From:
Sent: 13 November 2025 18:21
To: Louise Bearcroft; DC Admin; Waste Planning
Subject: Objection to Planning Applications 2025/61/92713/E and 2025/44/92737E - -Moor Lane, Gomersal

Objection to Planning Applications 2025/61/92713/E and 2025/44/92737E

Bin Collection Points and Bin Drag Distances

Drainage Layout

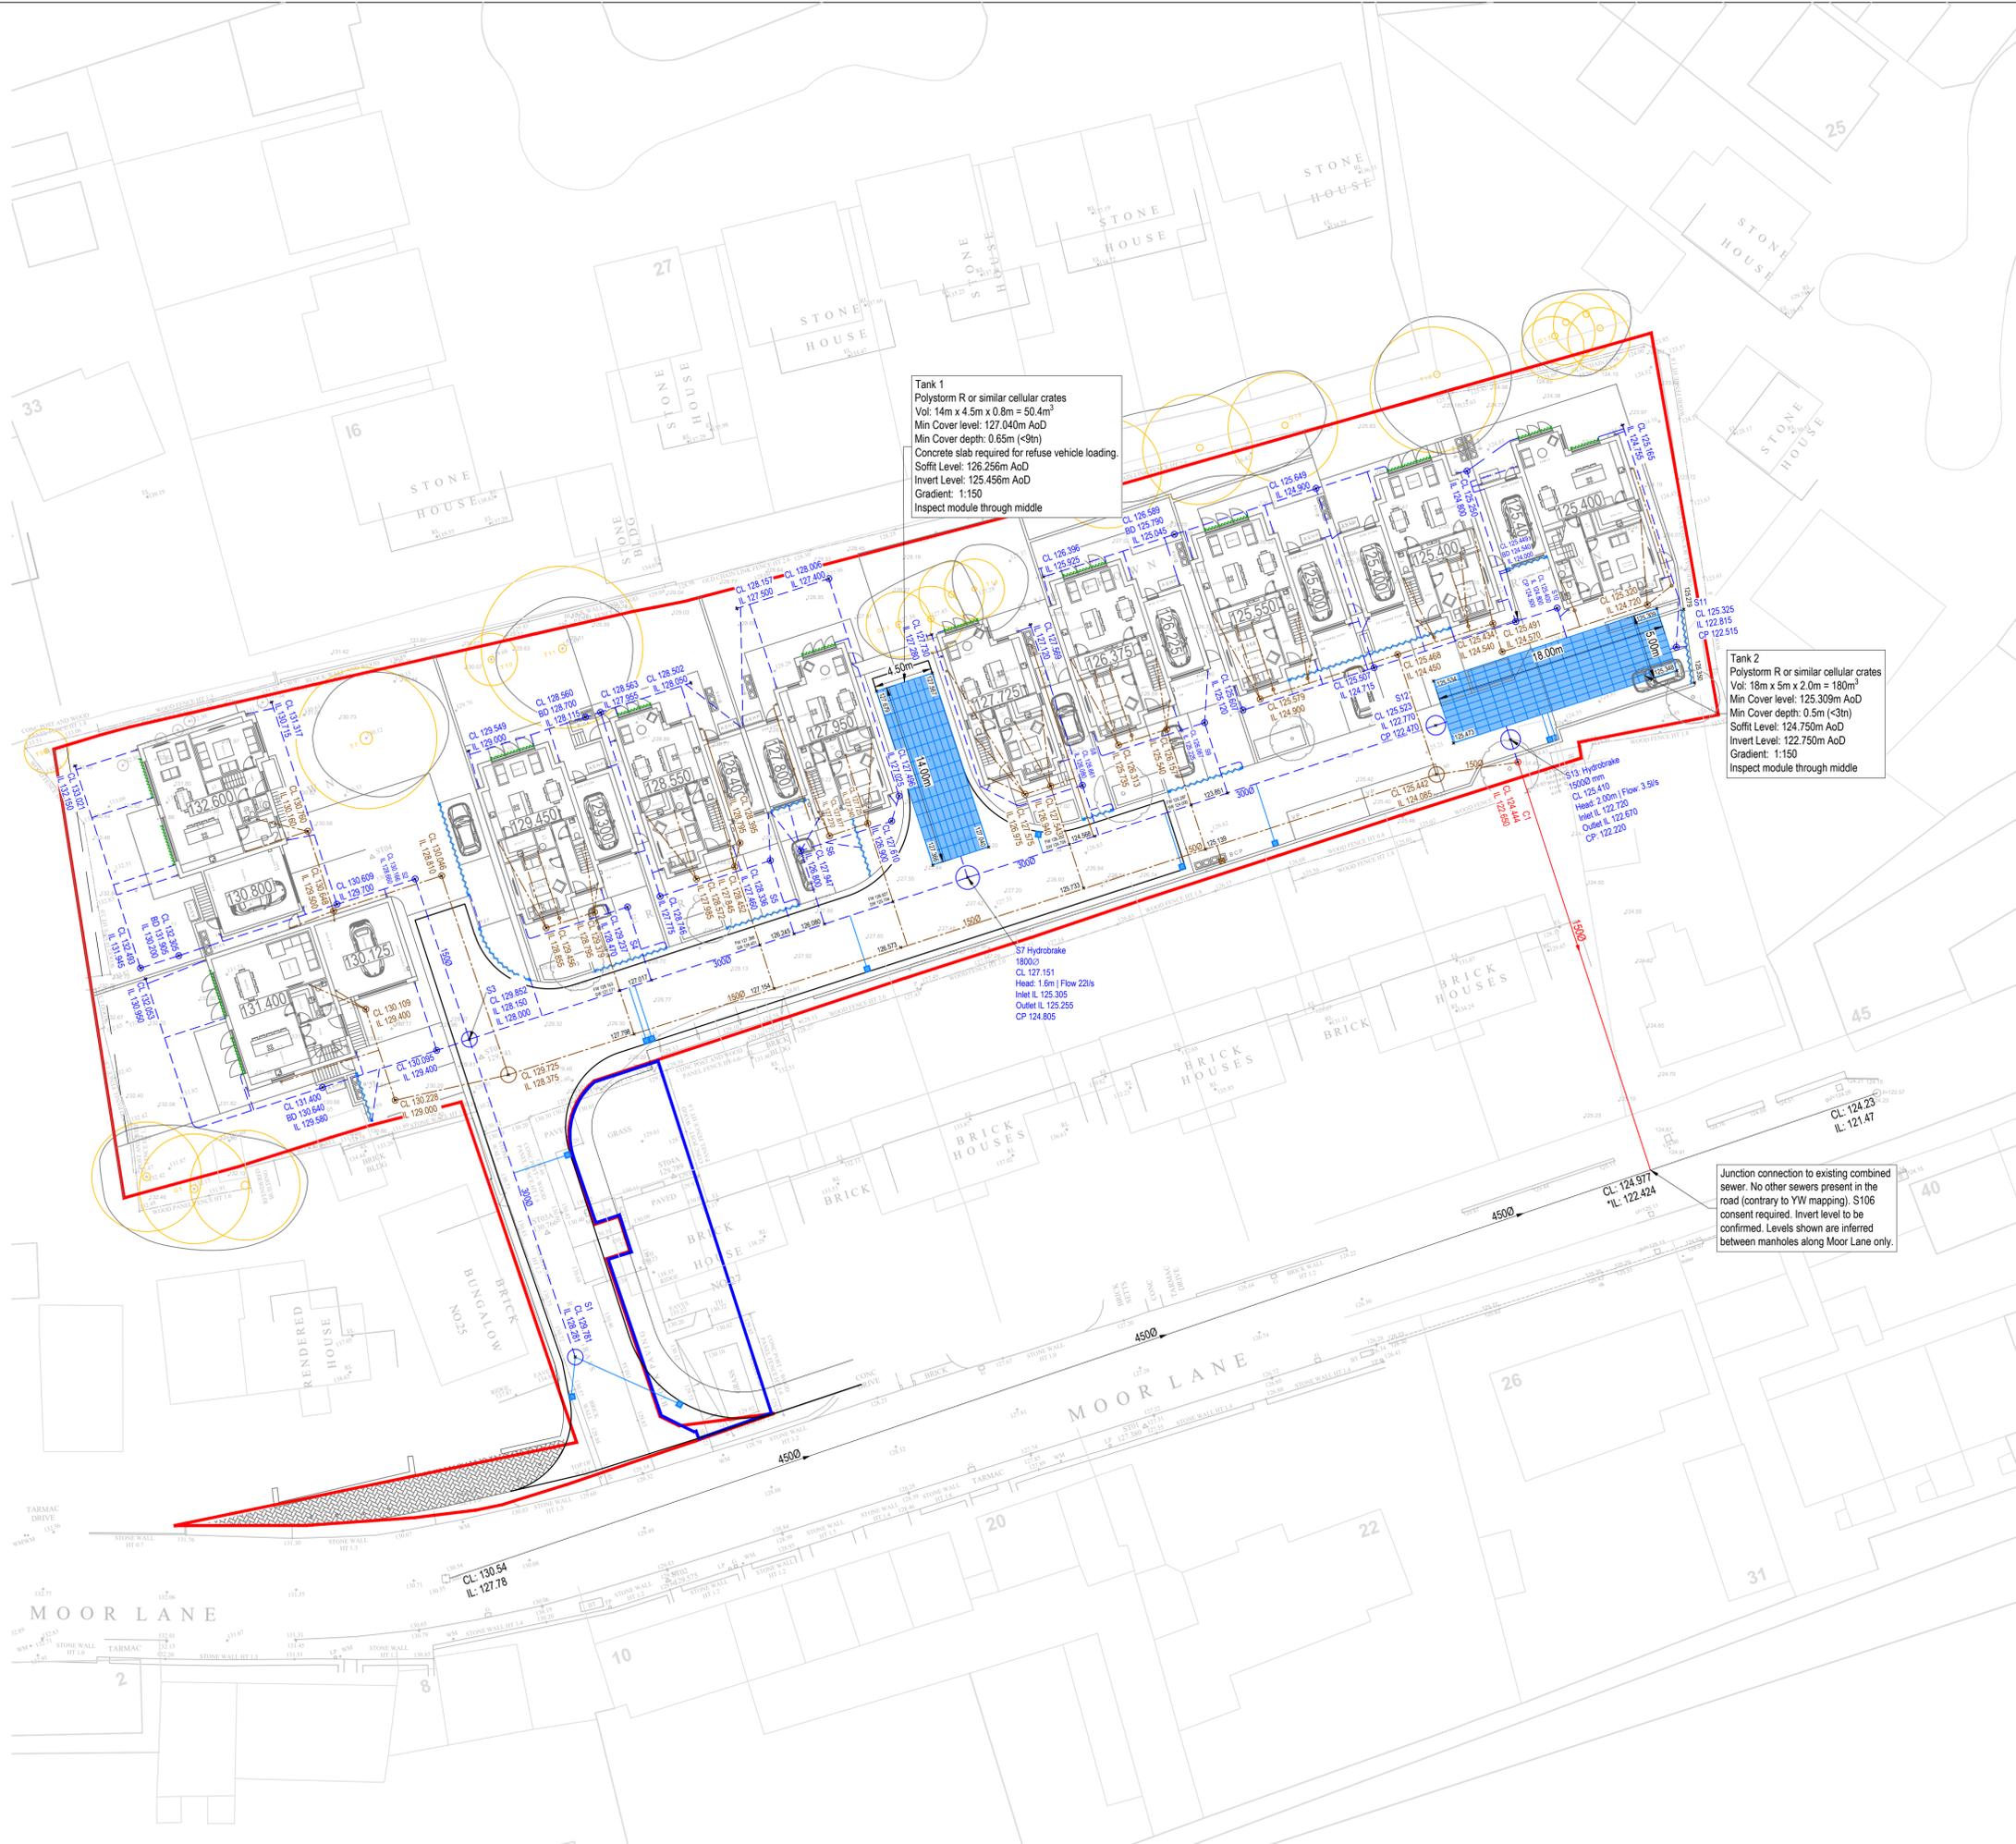
Plot 7, 8 9 and 10 are located down a private drive which will mean residents will have to drag their bins to the bin collection point, located at the end of the private drive.

The drags distance for plot 8, 9 and 10 all exceed this maximum 25metre.

Plot 10 - minimum 57 metres (excluding pathway widths)

Plot 9 - minimum 34 metres (excluding pathway widths)

Plot 8 - minimum 27.5 metres (excluding pathways widths)

Therefore only Plot 7's drag distance is below the maximum allowable drag distance of 25 metres and Plots 8,9 &10 all exceed the maximum allowable drag distance.
